Our Ref: FG/44/19/CLP

**Town & Country Planning Act 1990 (as amended)
Town & Country Planning (Development Management Procedure) (England) Order 2015 - Article
39**

Application for Lawful Development Certificate for a Proposed Use or Development

Location Protacol 5 The Pantiles Ferringham Lane Ferring

Protacol, The Pantiles, 5,
Ferringham Lane, Ferring,
Worthing, BN12 5NE

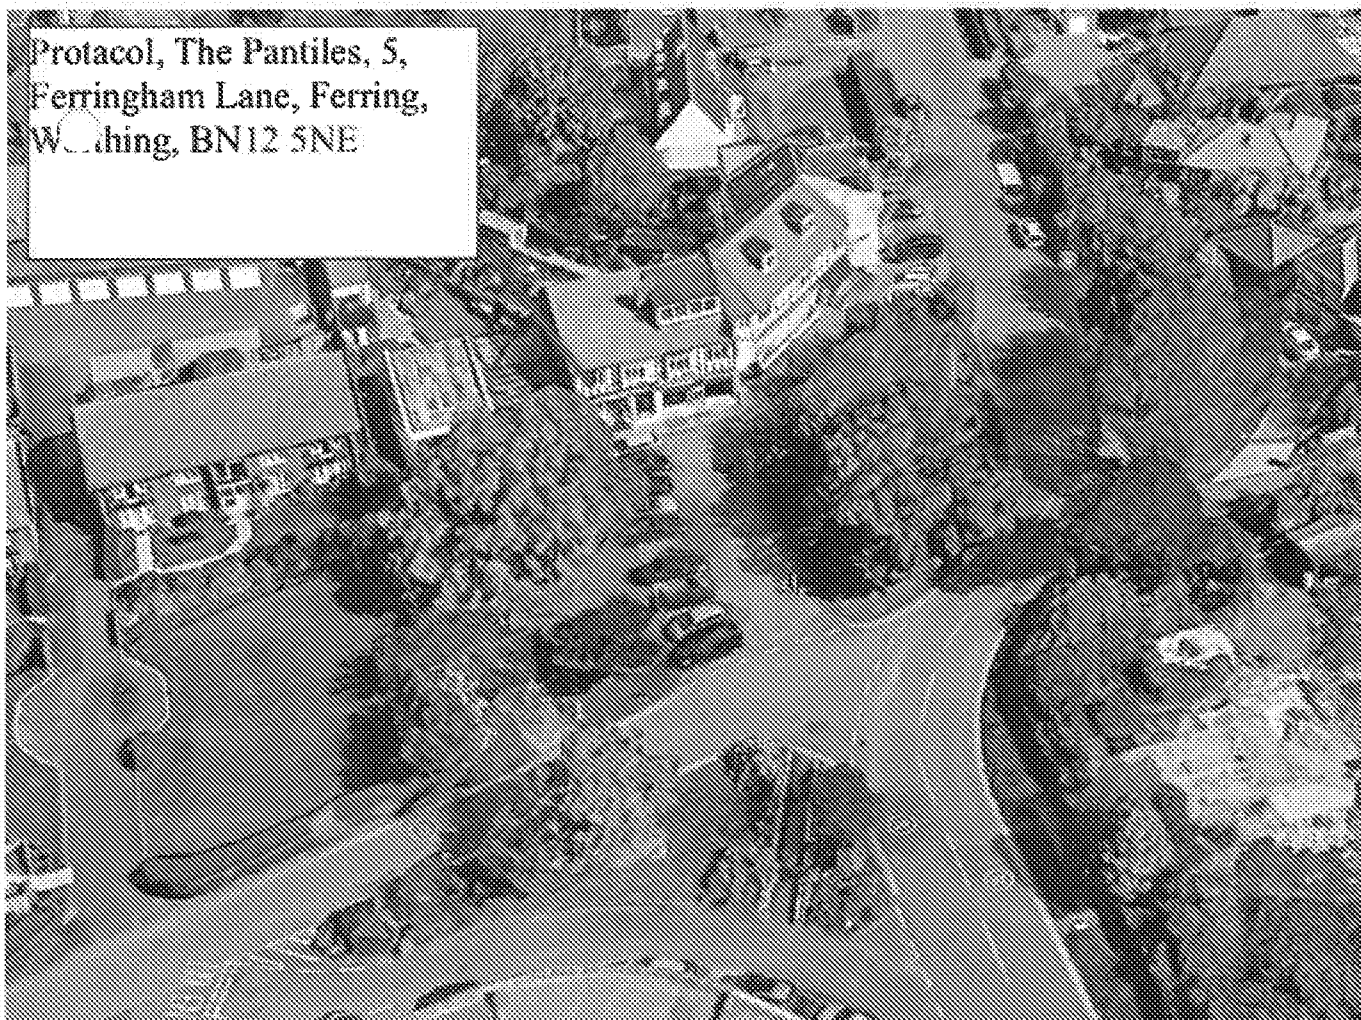
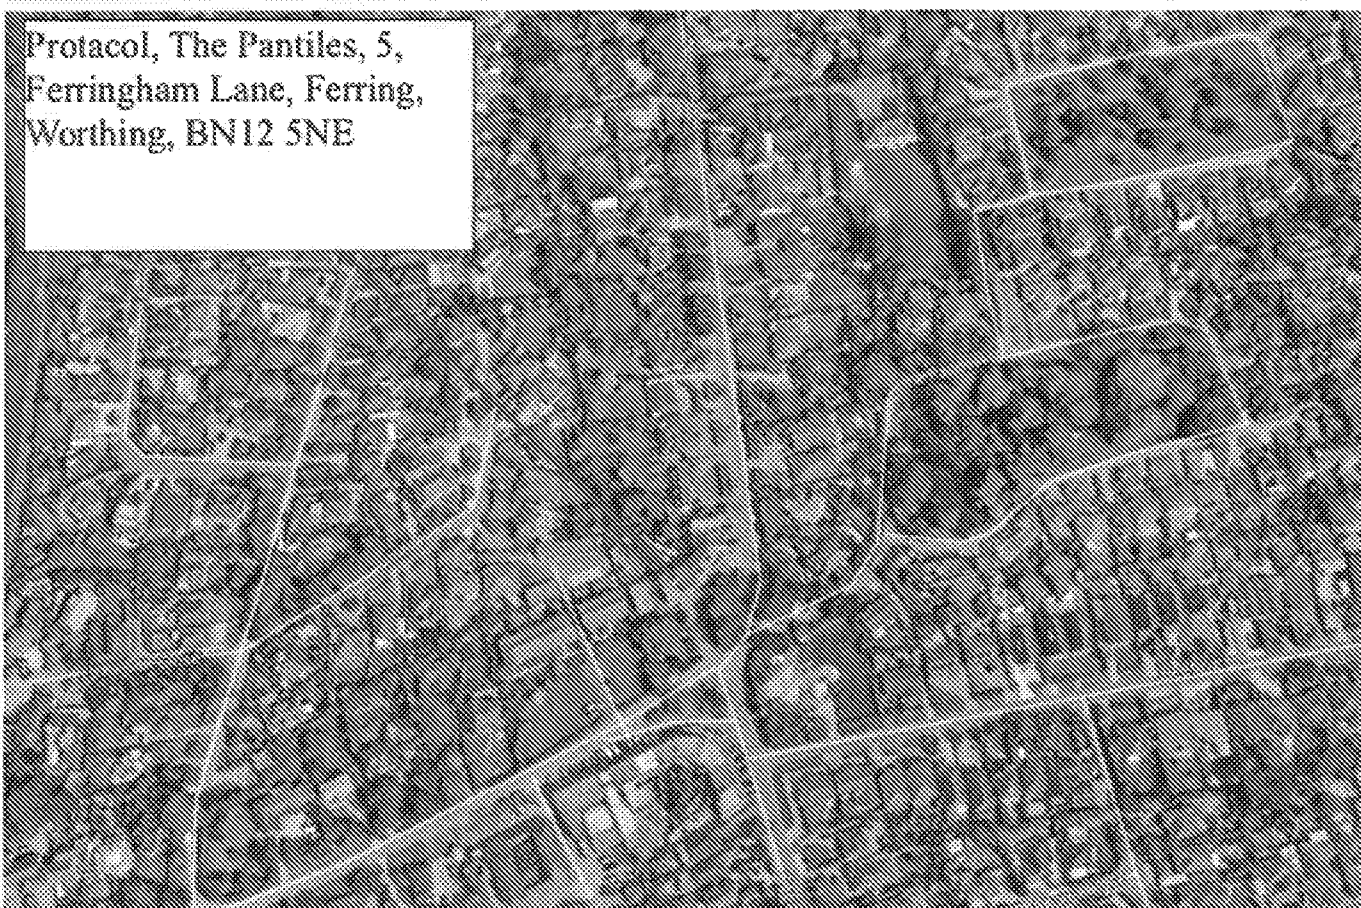
Please provide a plan/photo to show the existing elevations of the windows and door to be replaced.

Aluplast Casement

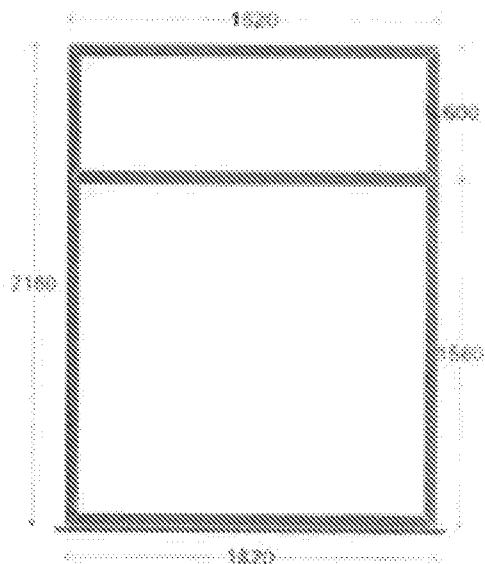
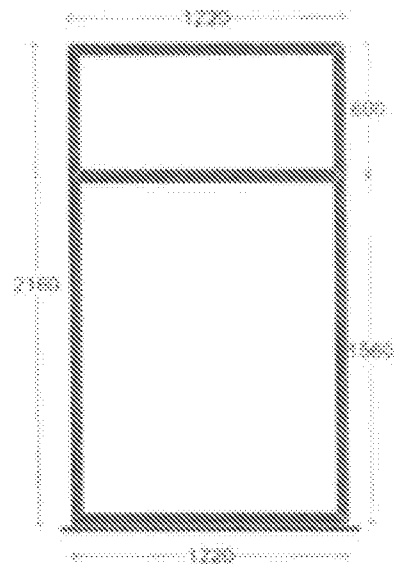
Please provide full details of the exact replacement windows and door including the colour.

Protocol. 5. The Pantiles, Ferringham Lane, Ferring, West Sussex. BN12 5NE

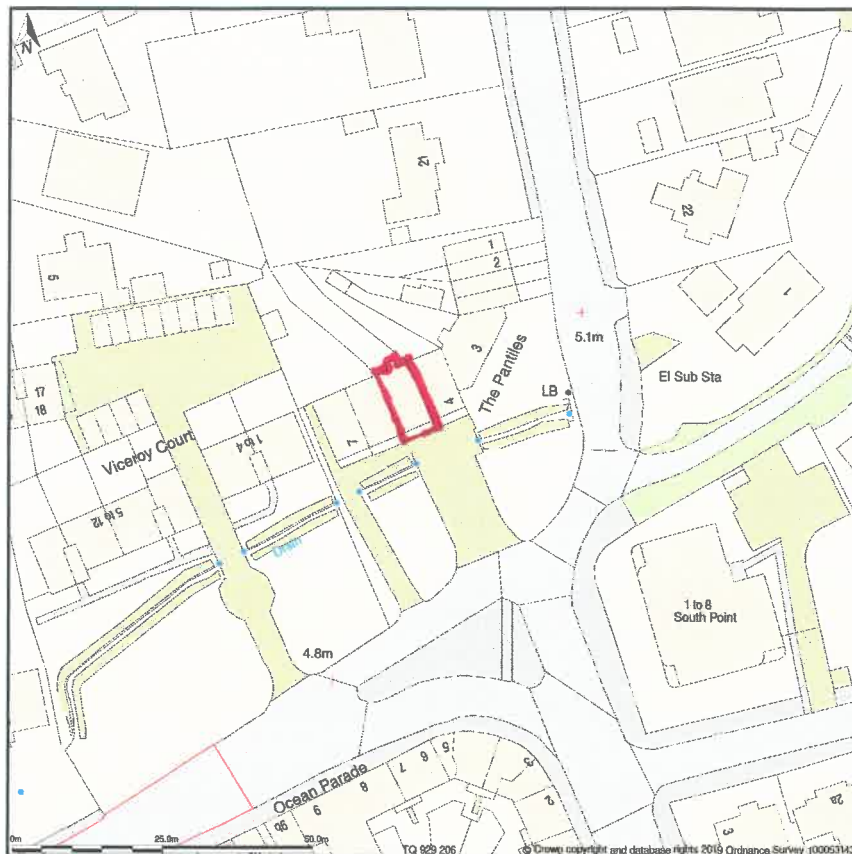
Please provide a plan identifying the land to which the application relates, drawn to an identified scale and showing the direction of North.
